**KIRKLEES METROPOLITAN COUNCIL
INVESTMENT & REGENERATION SERVICE**

DELEGATED DECISION TO DETERMINE PLANNING APPLICATIONS

Reference No:	2024/62/90389/W
Site Address:	25, Ivy Street, Crosland Moor, Huddersfield, HD4 5RB
Description:	Erection of staircase to front elevation with replacement porch roof and alterations (retrospective)
Recommending Officer:	Laura Yeadon

DECISION - REFUSE

Retrospective Proposed Front Elevation
1 : 50

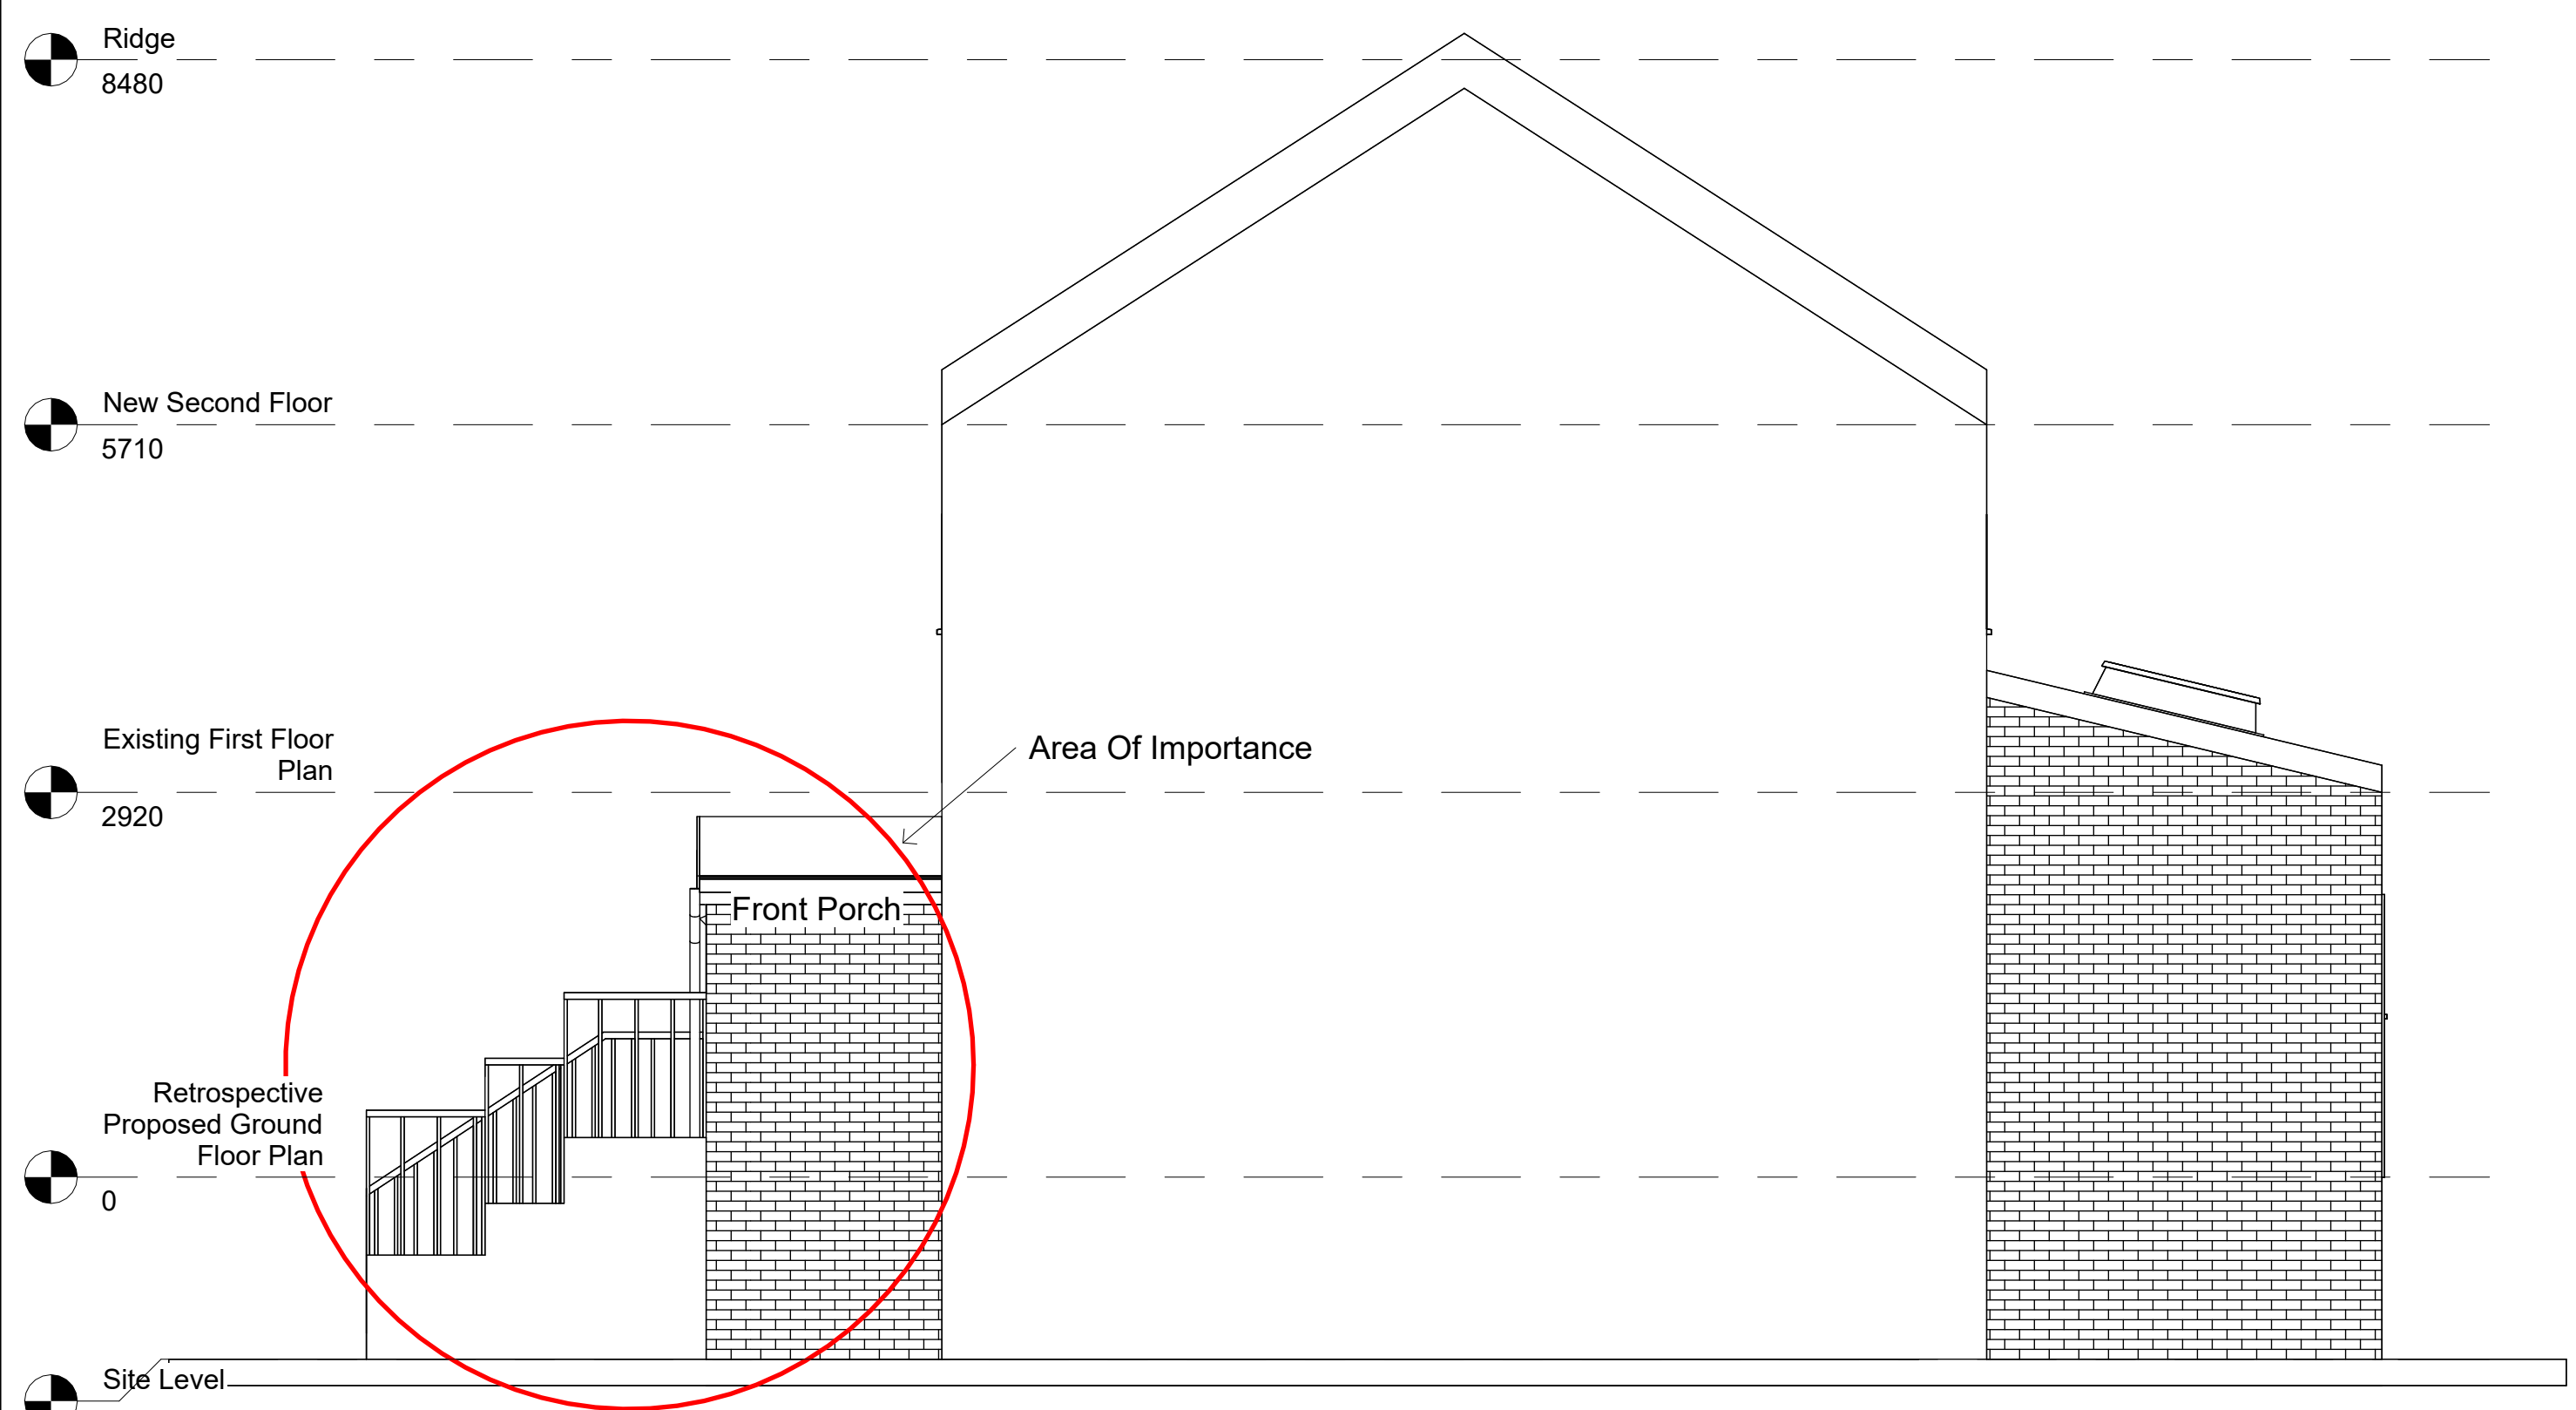
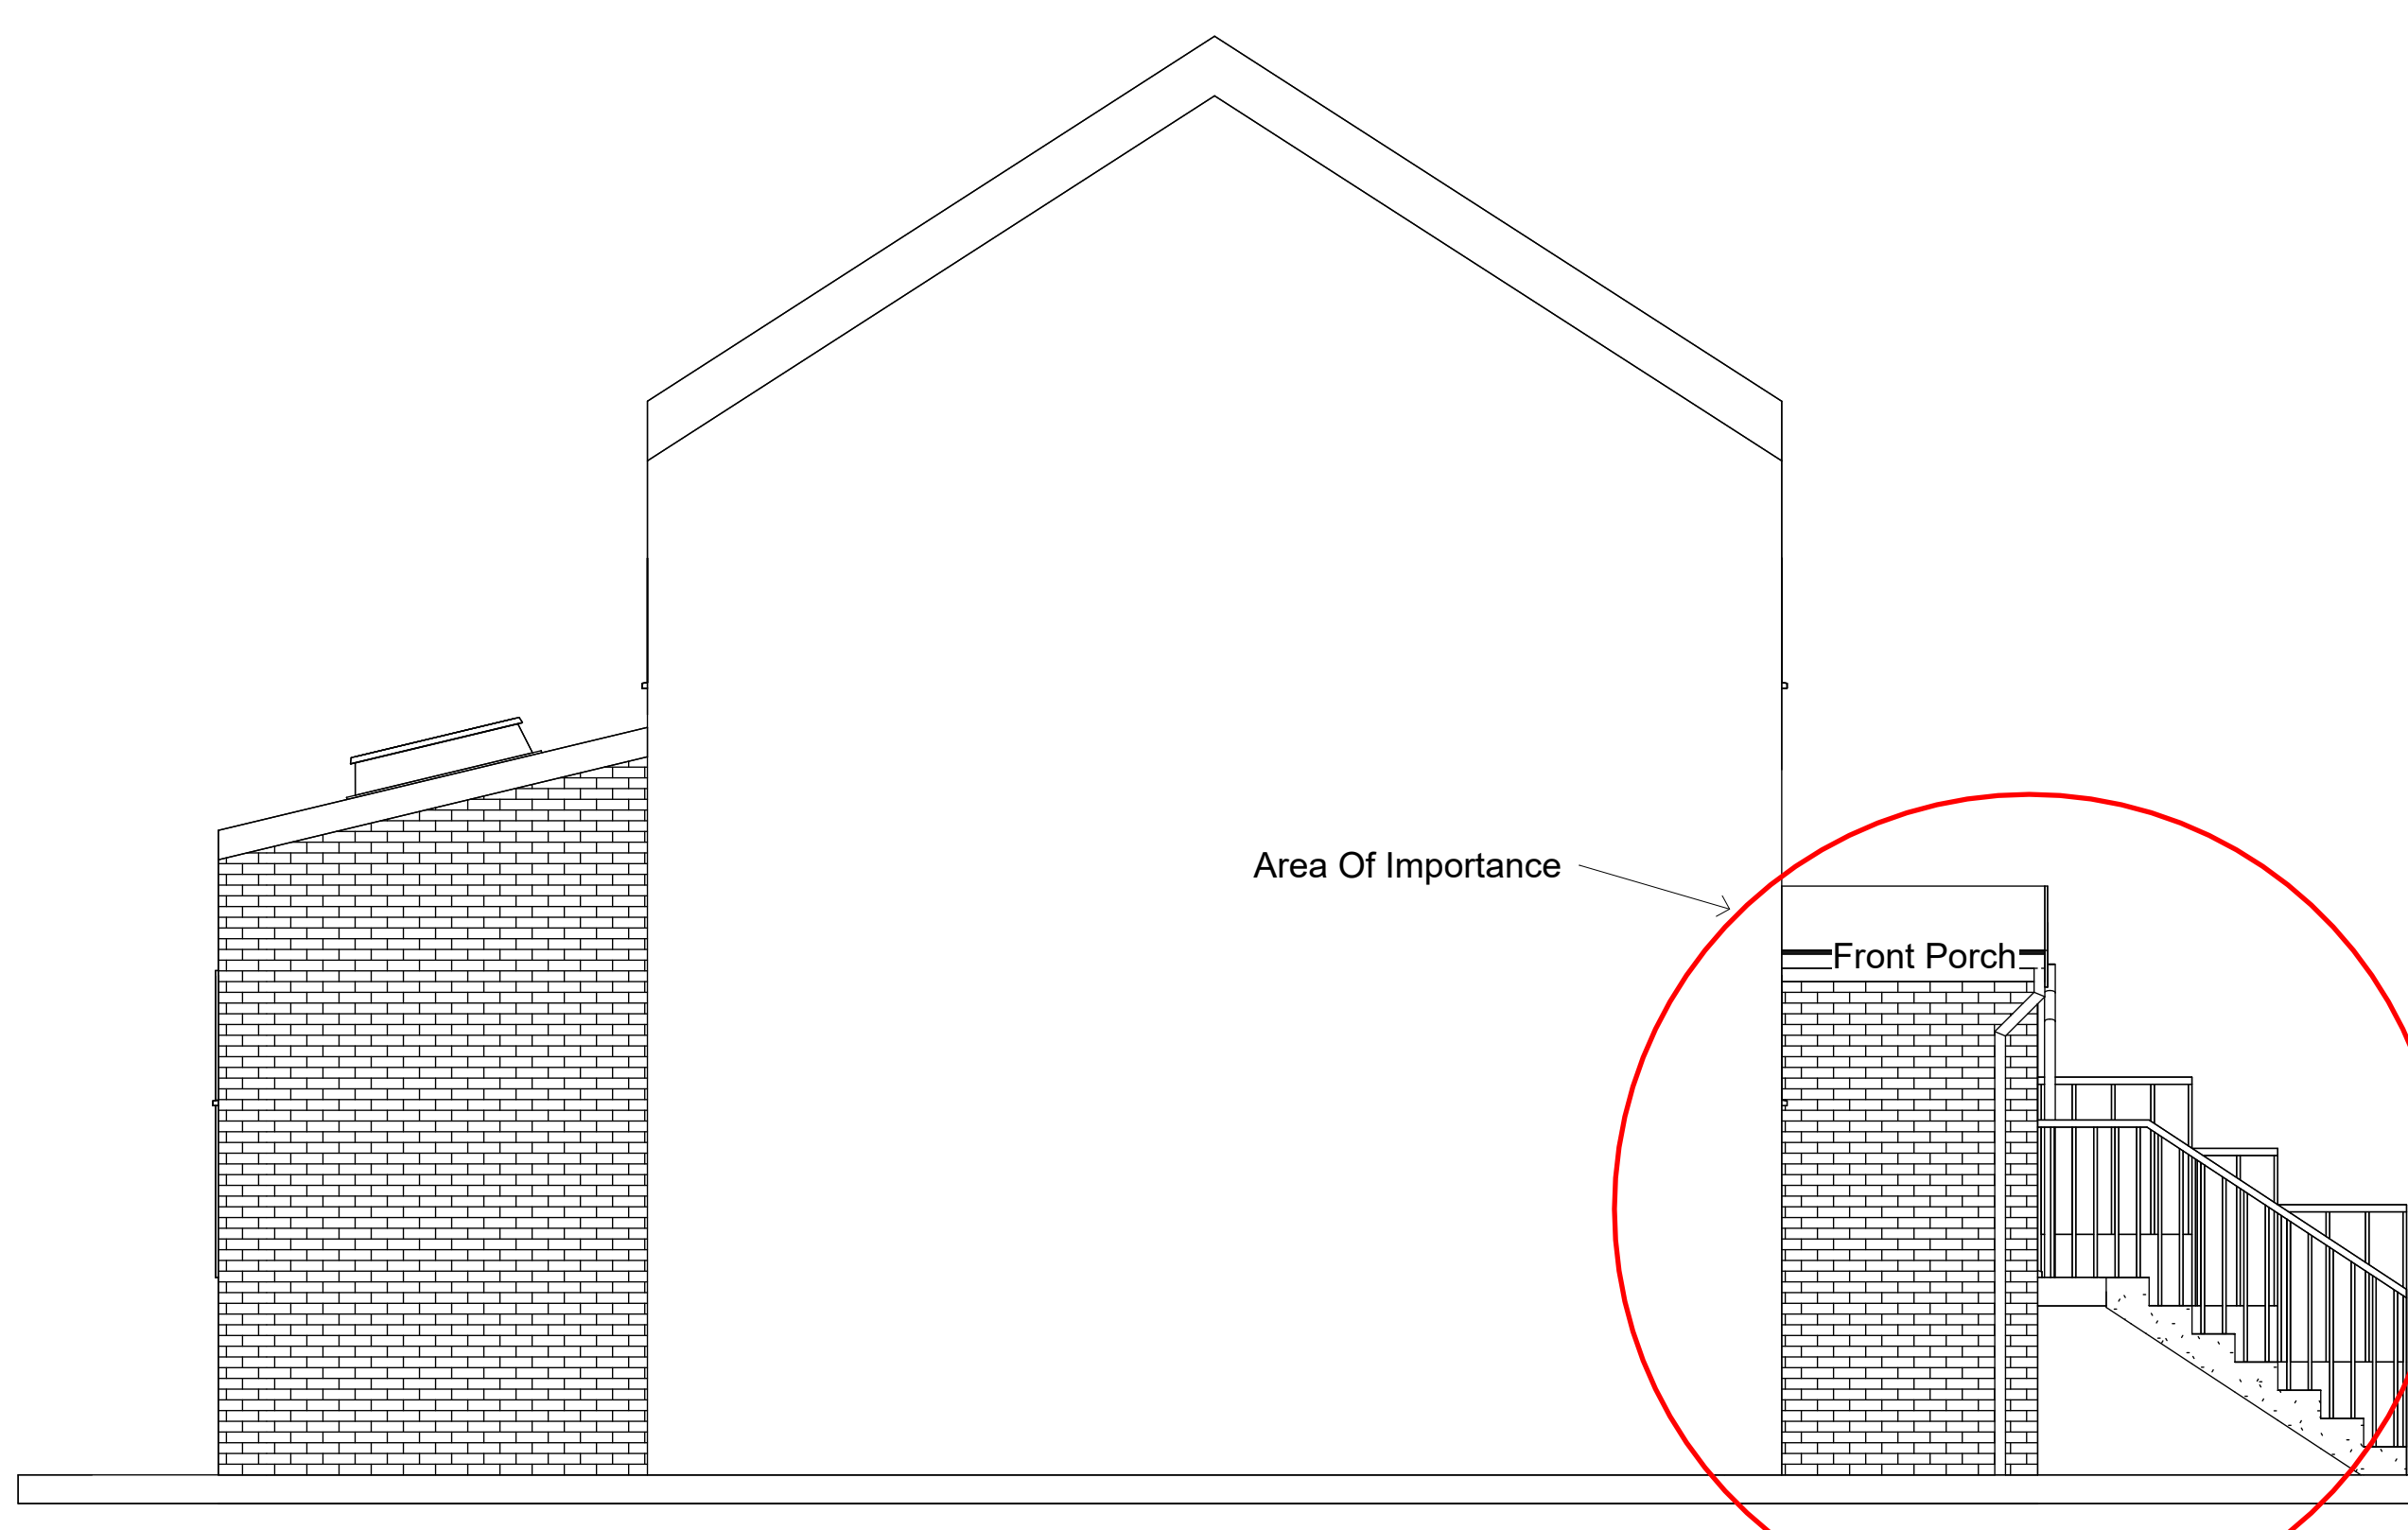
The creation of the staircase extends forward of the front elevation of the porch by an additional 2.6 metres which results in a prominent structure within the street scene. There is a uniformity of flush front elevations within the terraced row which does not host any other front porches. Due to the prominence and depth of the staircase, in conjunction the pitched roof which has more visual

impact than the simple lean-to roof as previously approved, the works in totality would detract from the visual amenity of the area and forms an overly prominent and incongruous feature with a resultant adverse visual impact that would be contrary to Policy LP24 (a) of the Kirklees Local Plan. This Policy states that the form, scale, layout and details of all development should respect and enhance the townscape. This is further supported by the House Extensions and Alterations SPD which states that front extensions are highly prominent in the street scene and can erode the character of the area.

It is therefore considered that the cumulative impact of the staircase and alterations with the change of roof form would fail to comply with Policy LP 24 (a and c) of the Kirklees Local Plan, Key Design Principles 1 and 2 of the House Extensions and Alterations SPD and advice within Chapter 12 of the NPPF.
